CITY OF PORTLAND, MAINE

October 6, 2017

Project Name:	0 Hancock Street (Wex)	Project ID:	2017-180
Address:	0 Hancock Street	CBL:	019 A0014
Applicant:	0 Hancock Street, LLC, Jonathan Cohen		
Planner:	Caitlin Cameron

D BRICK DRIVEWAY APRON WITH BITUMINOUS BASE
 N.T.S.

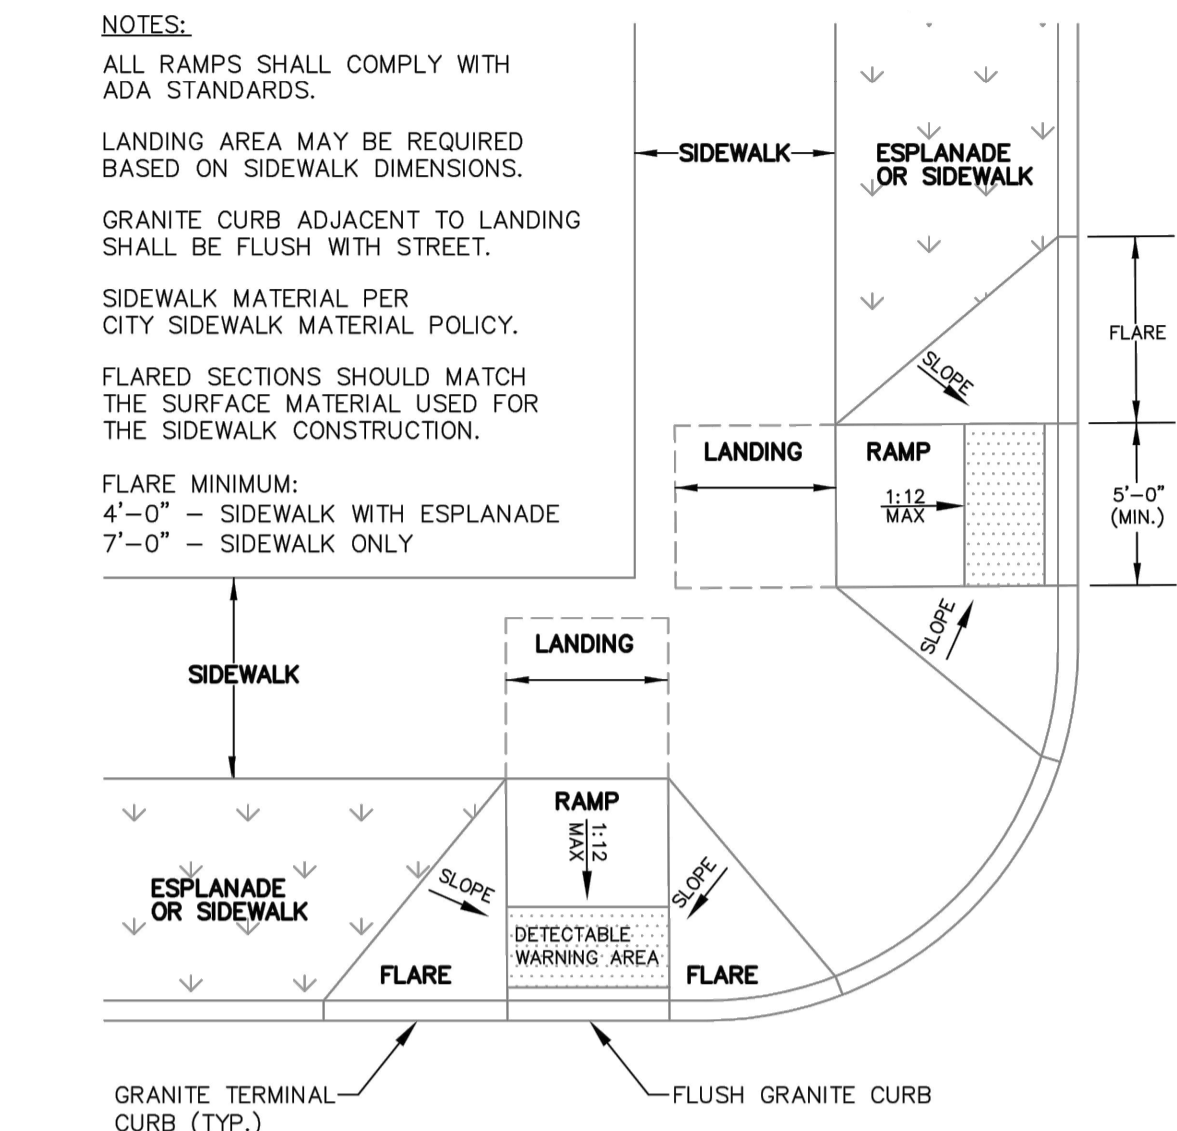
- the driveway on Hancock Street is to carry brick across the applicant's driveway per the new sidewalk material policy, have a maximum cross-slope of 2% for the pedestrian access route and the sidewalk on each side of the driveway is to ramp down (not introduce a flare as currently shown) - the detail for the driveway is to reflect these items

E BRICK SIDEWALK WITH BITUMINOUS BASE
 N.T.S. AS OBTAINED FROM THE CITY OF PORTLAND "TECHNICAL MANUAL"

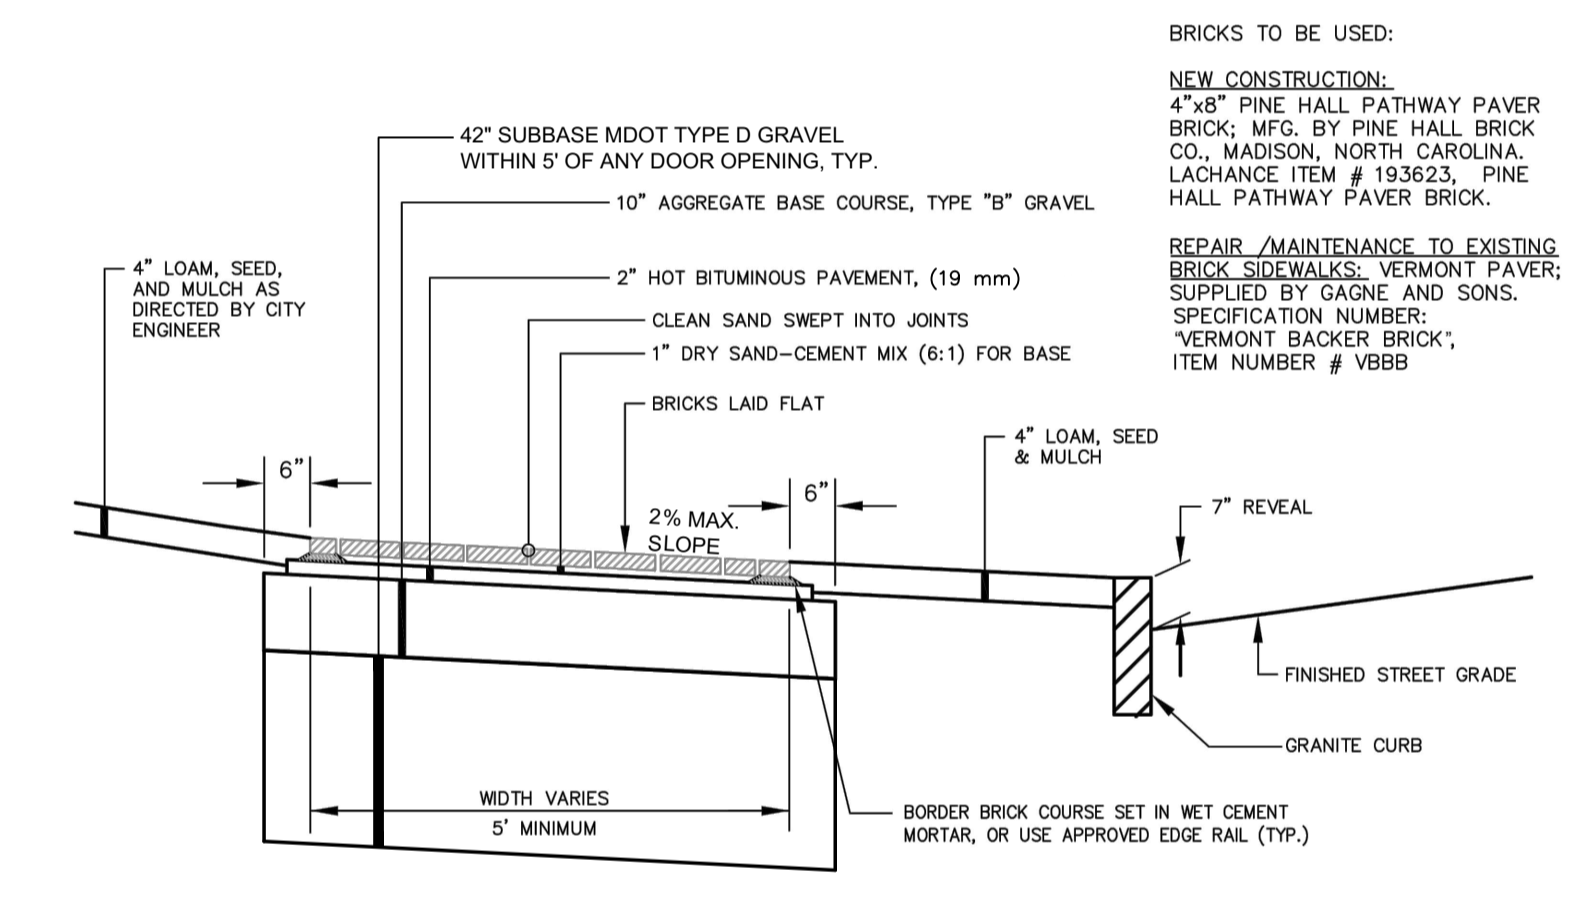
- the brick sidewalk detail is to note a maximum cross-slope of 2%.

H SIDEWALK RAMP DETECTABLE WARNING PANEL
 N.T.S. AS OBTAINED FROM THE CITY OF PORTLAND "TECHNICAL MANUAL"

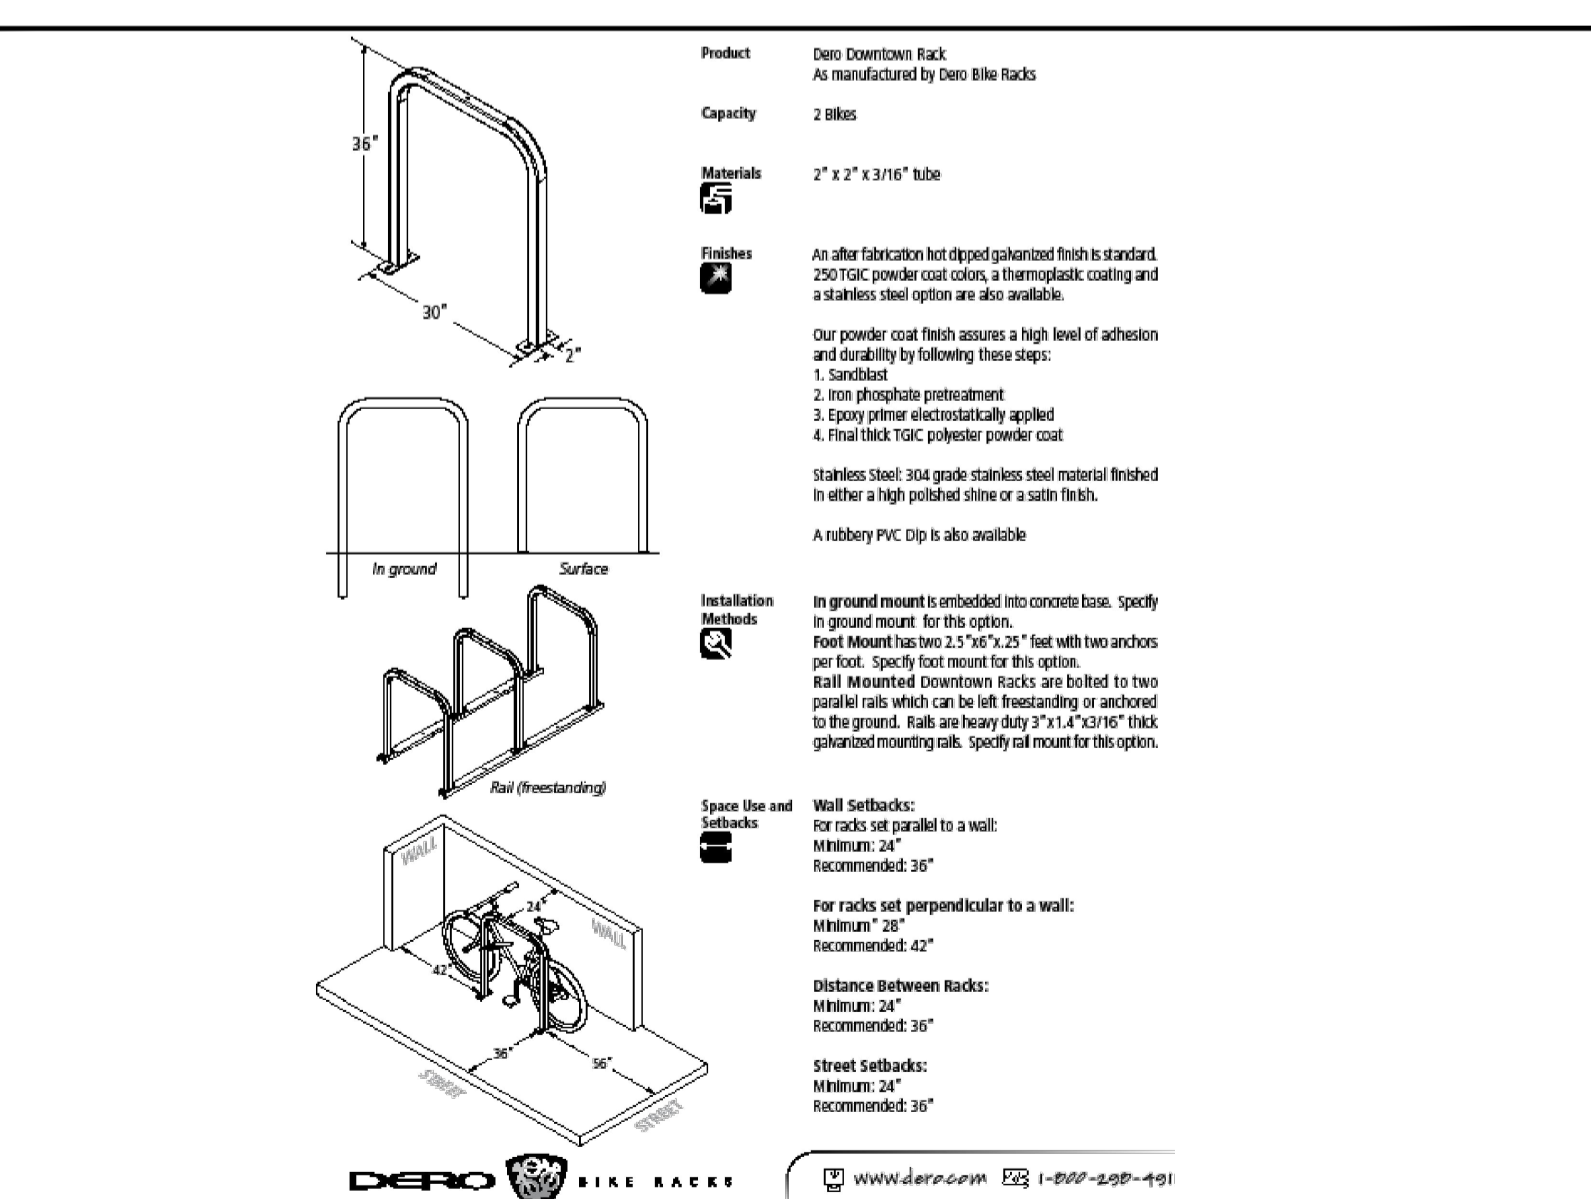
- the detectable warning panel within the existing curb ramp at the corner of Fore-Hancock Streets (SE corner) is to be replaced (cast iron, per new curb ramp detail) to create a direct and fully ADA-accessible route from the WEX main entrance on Hancock Street to the Ocean Gateway Garage
